# WOODMOOR WATER AND SANITATION DISTRICT NO. 1

## WELL NO. 22

### SWMP, GRADING AND EROSION CONTROL PLAN

AUGUST 2023

SHEET NO.
C1.0

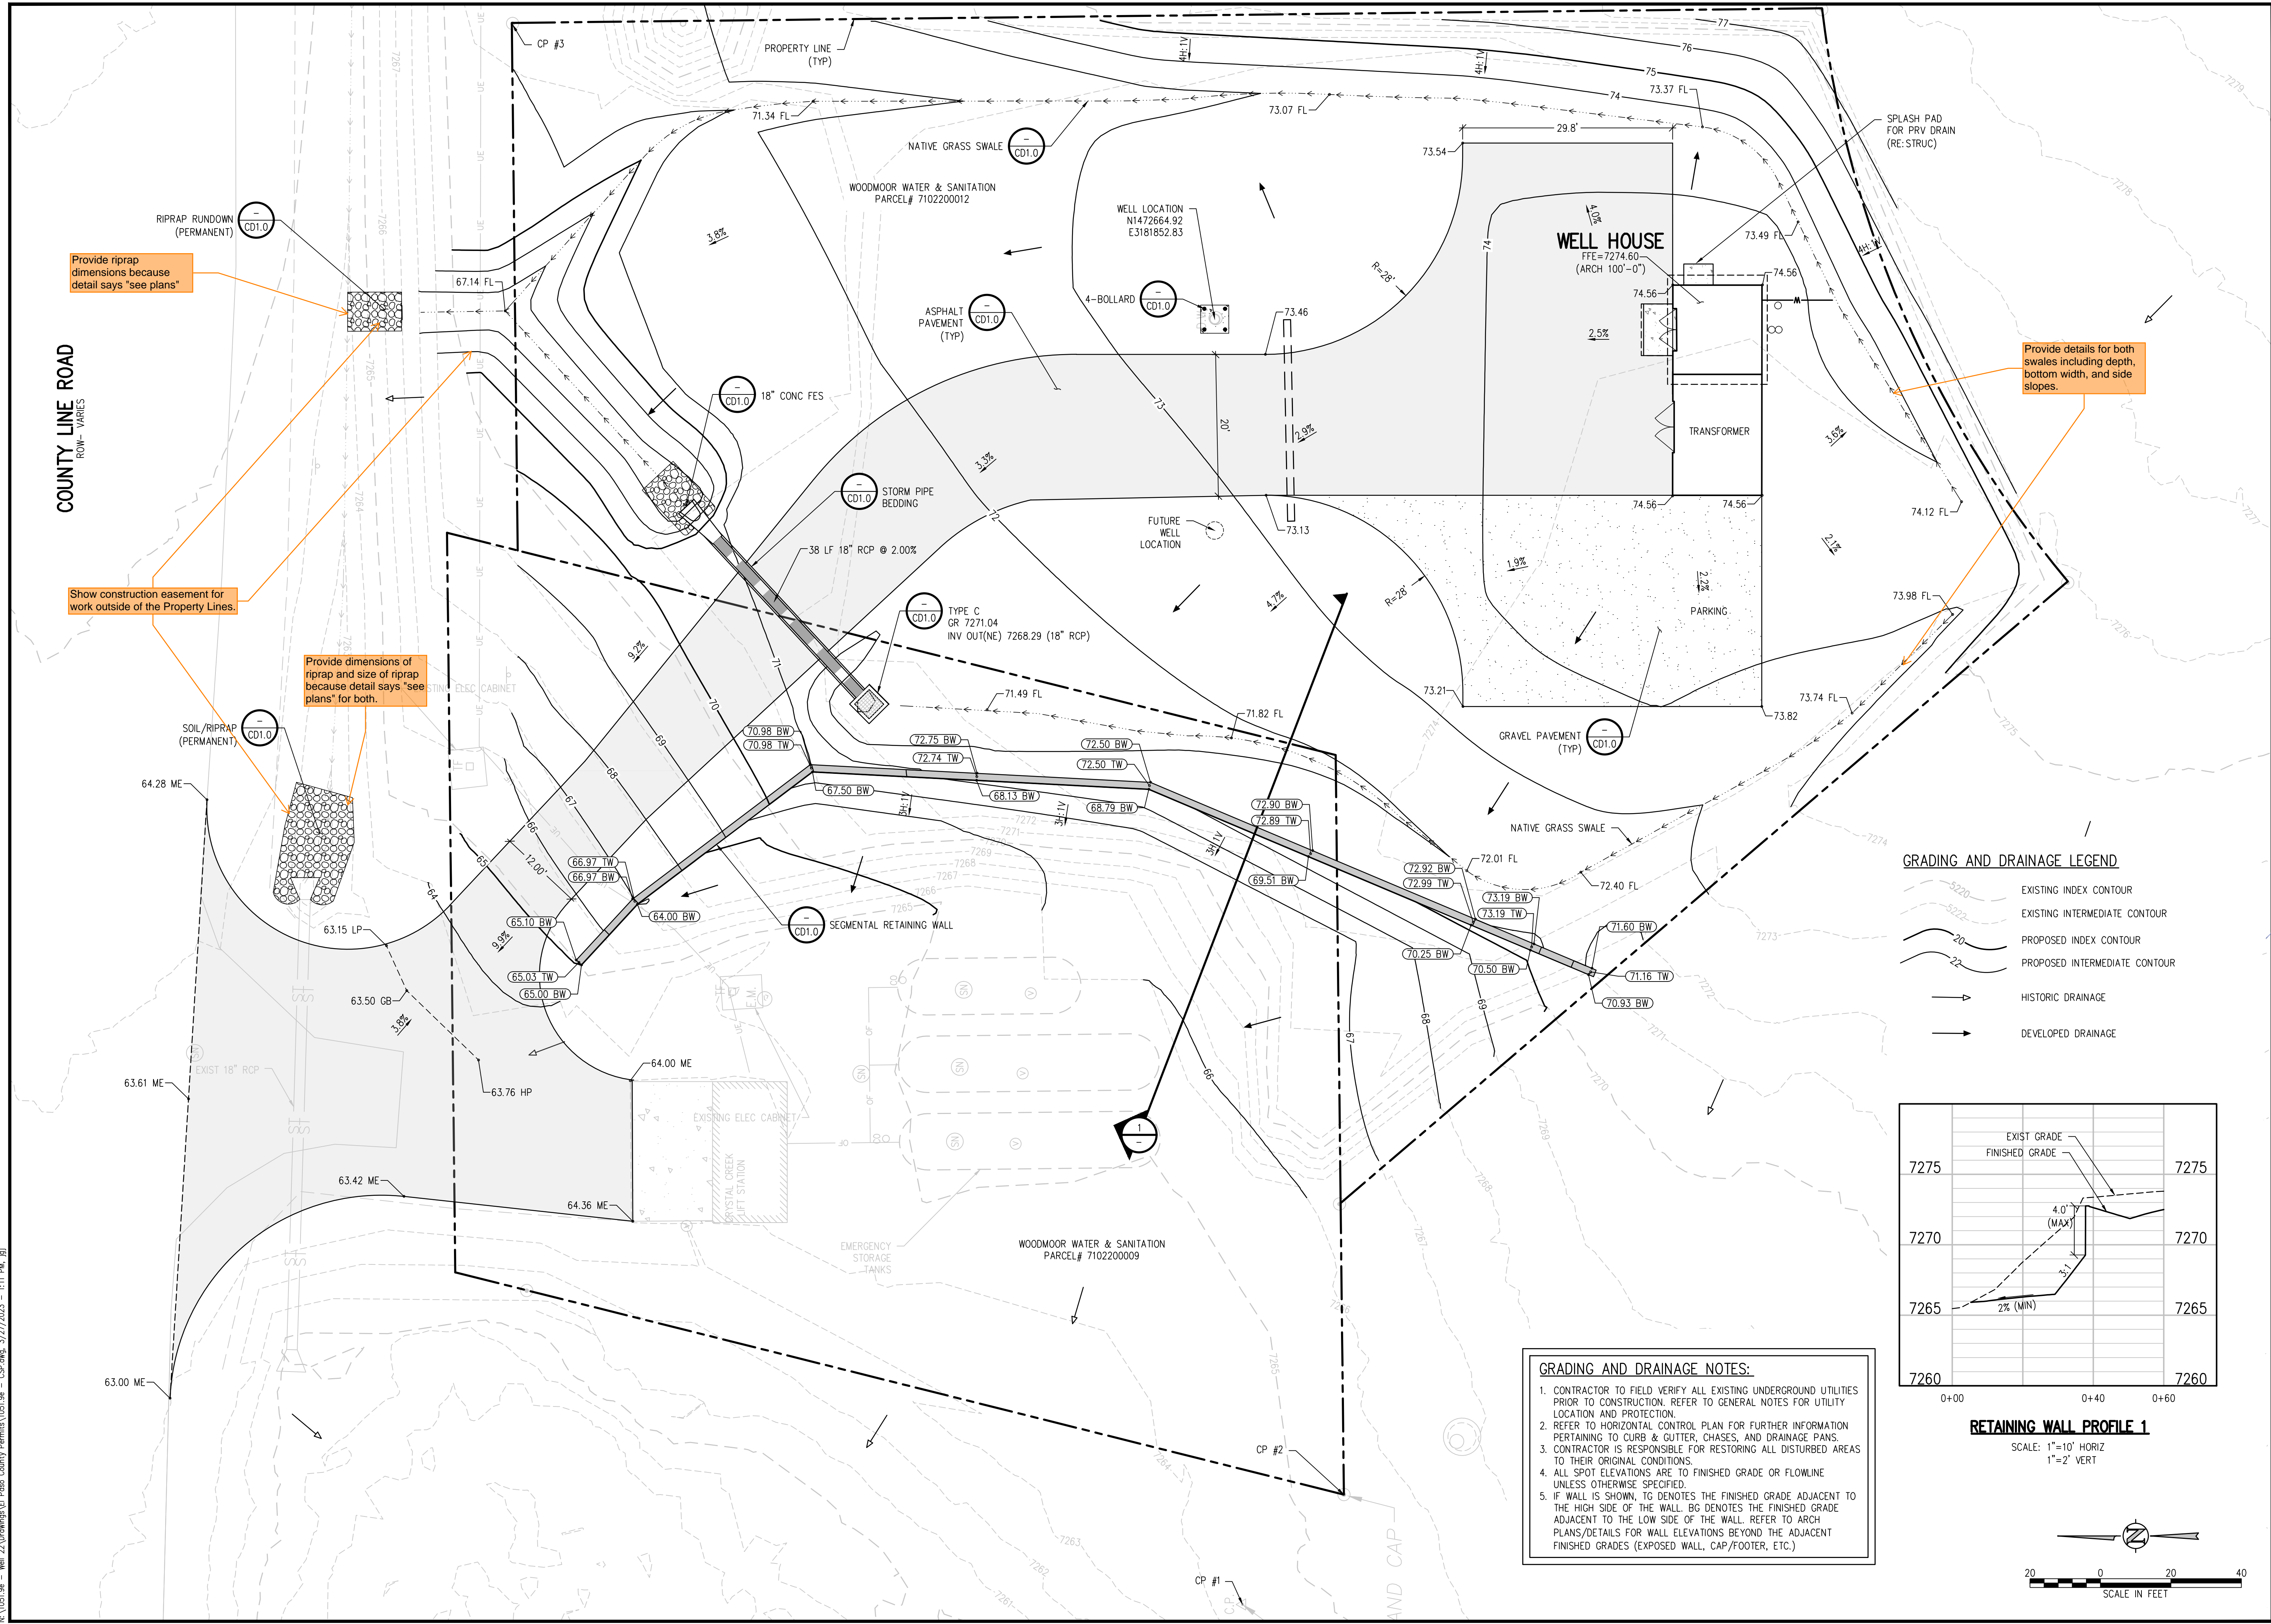
Unresolved from Submittal 1 and 2: Provide permanent riprap or other erosion protection in ditch at the discharge location.

Additional information per submittal 3: The discharge line is still in this location shown on the Site Development Plans. Since this location will be used for discharge, please place erosion protection measures downstream of this discharge location to prevent erosion at this location along the ditch.
